Application no: 22/00217/DISC

Location: Begbroke Science Park, Begbroke Hill, Begbroke, OX5 1PF

Lead Local Flood Authority

Objection

**ZONE B CATCHMENT AREAS PLAN**

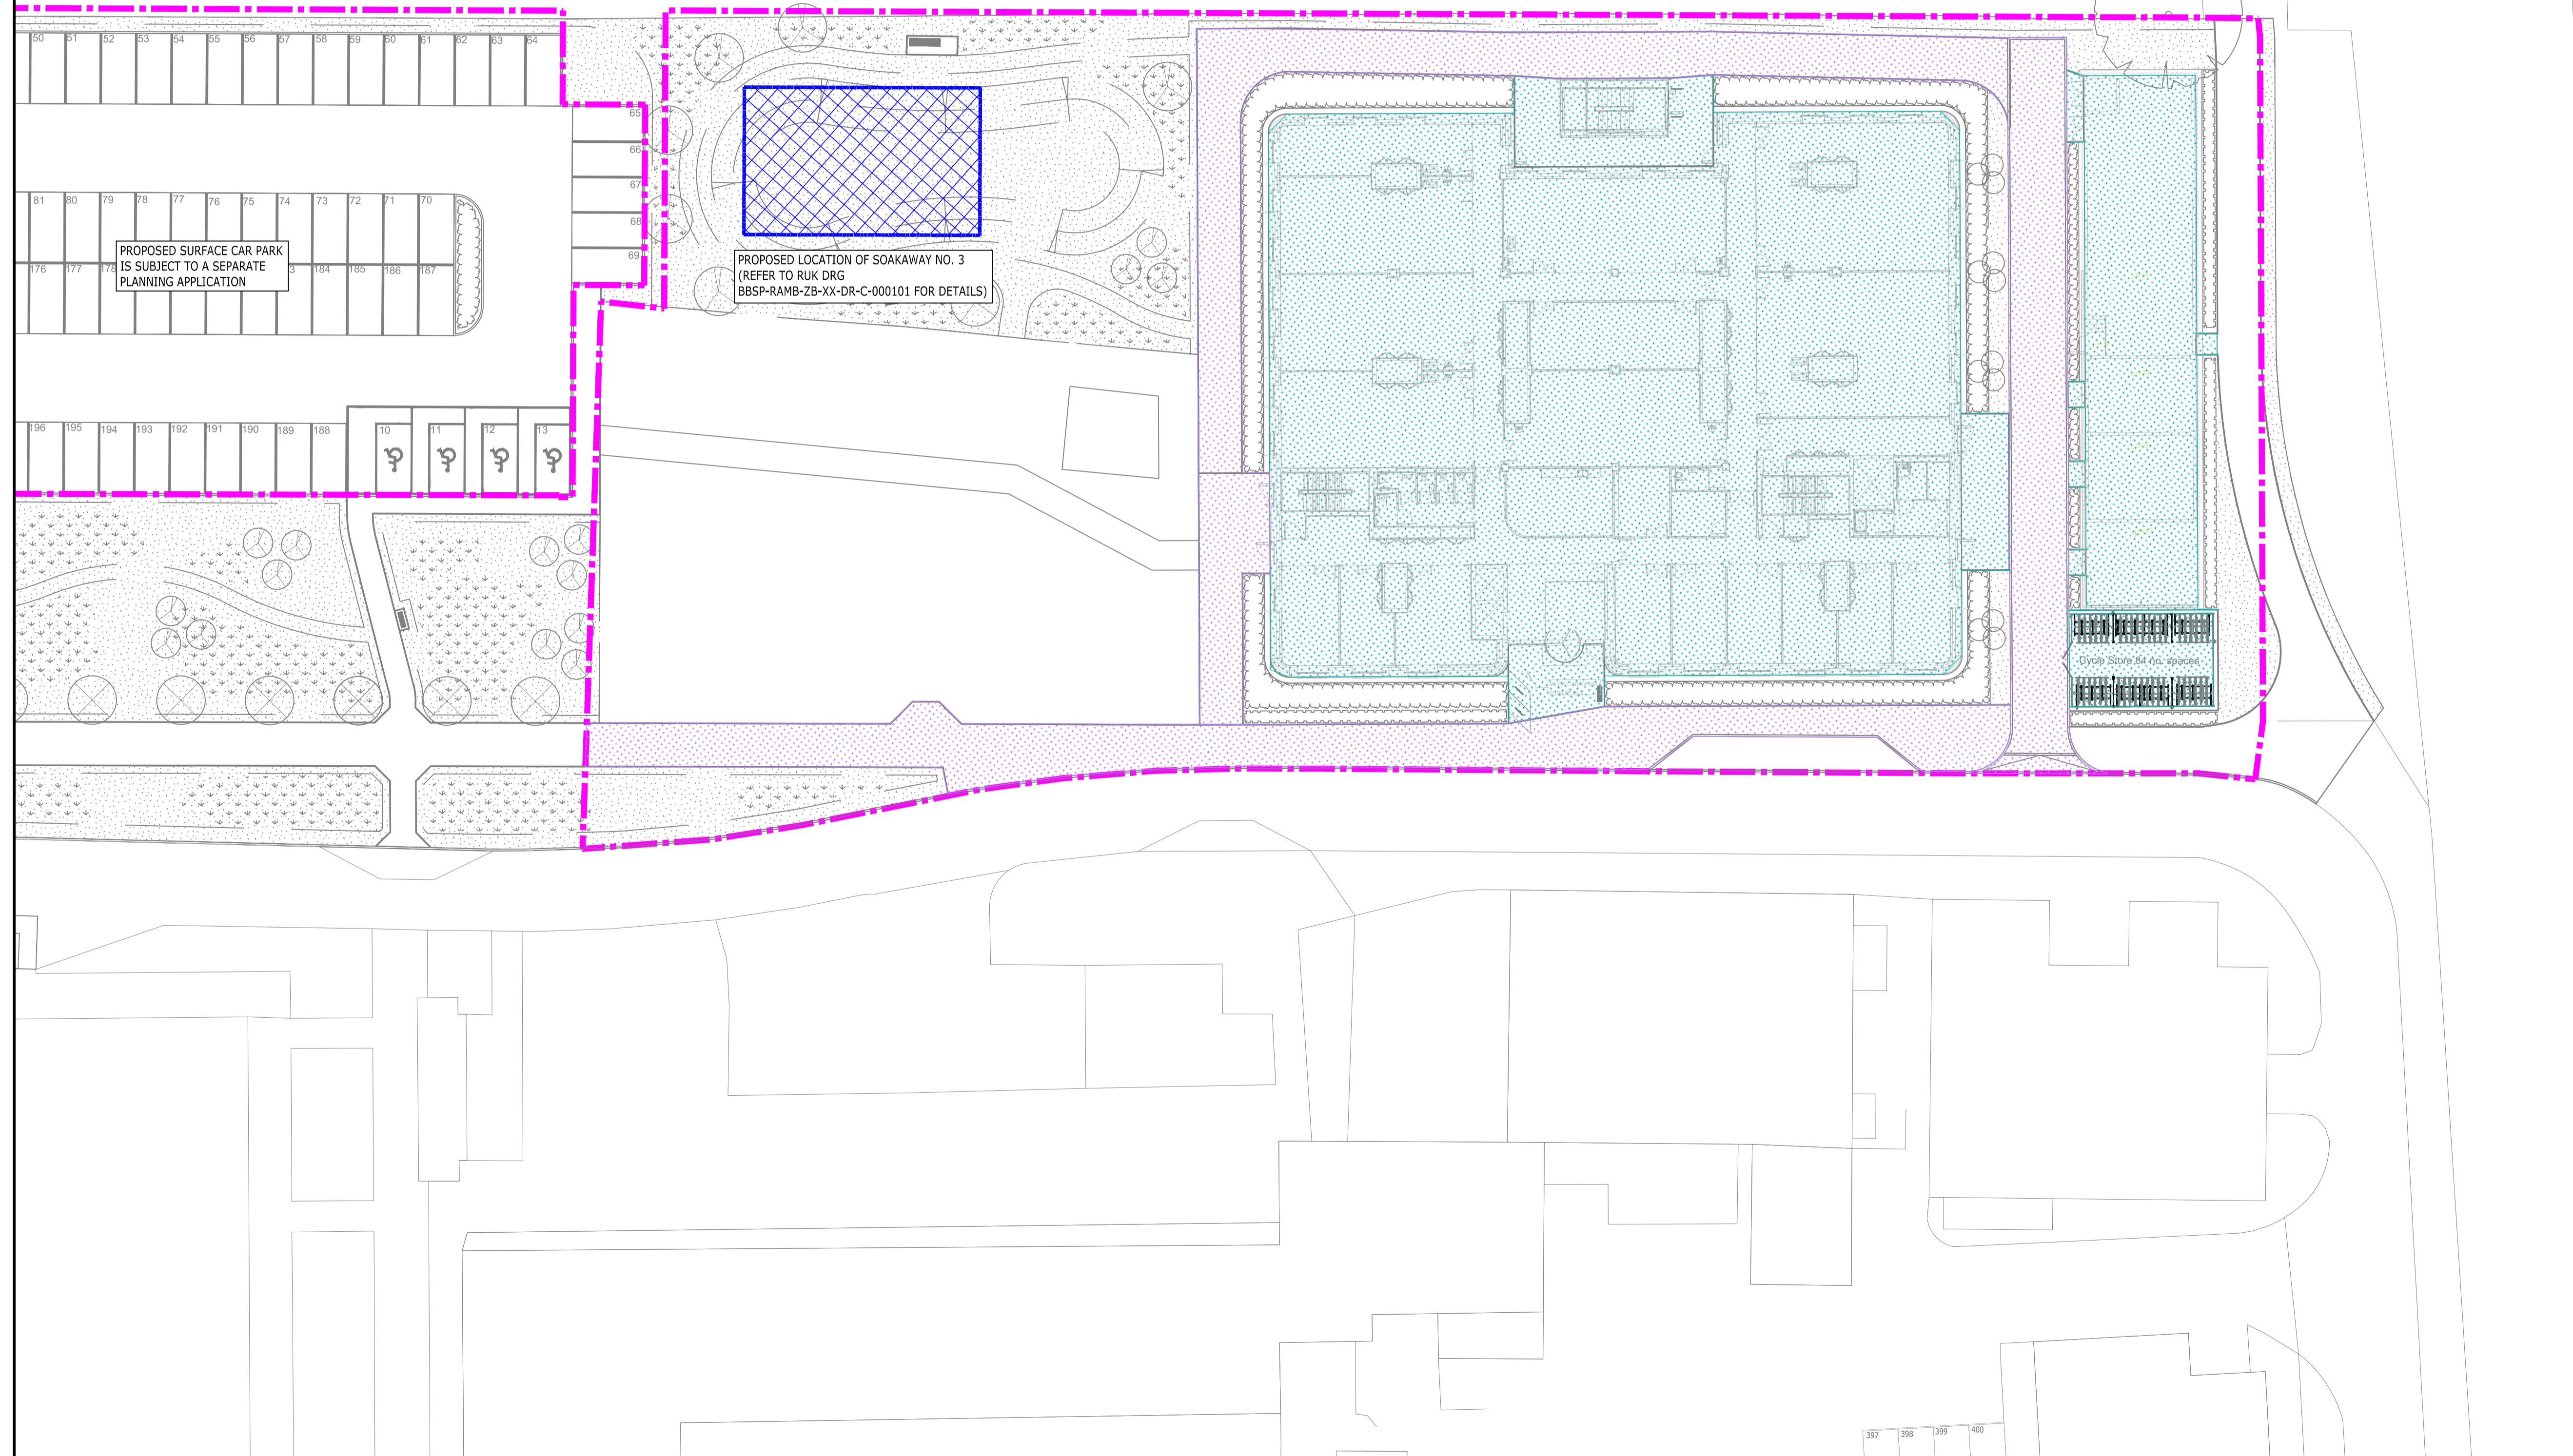
- o SUDS (Soakaways)
Provide catchment plan. There is a soakaway proposed outside the site boundary, please clarify ownership of this land and whether the proposed soakaway is acceptable.

**ZONE B INDICATIVE SURFACE WATER DRAINAGE LAYOUT**

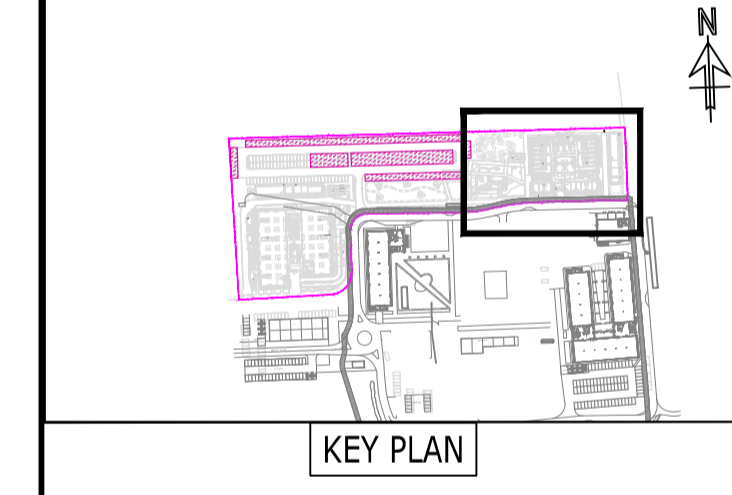
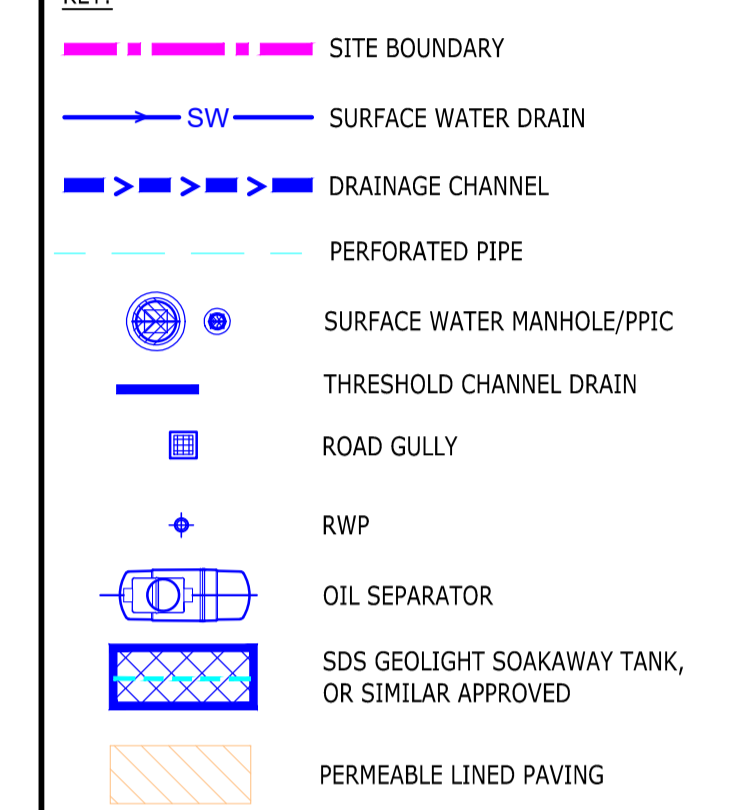
- o Detailed drainage layout with pipe numbers
Provide pipe numbers. Calculations should reflect the pipe references.
- o Network drainage calculations
Provide calculations for the drainage infrastructure and SuDS features for all storm events plus 40% climate change.
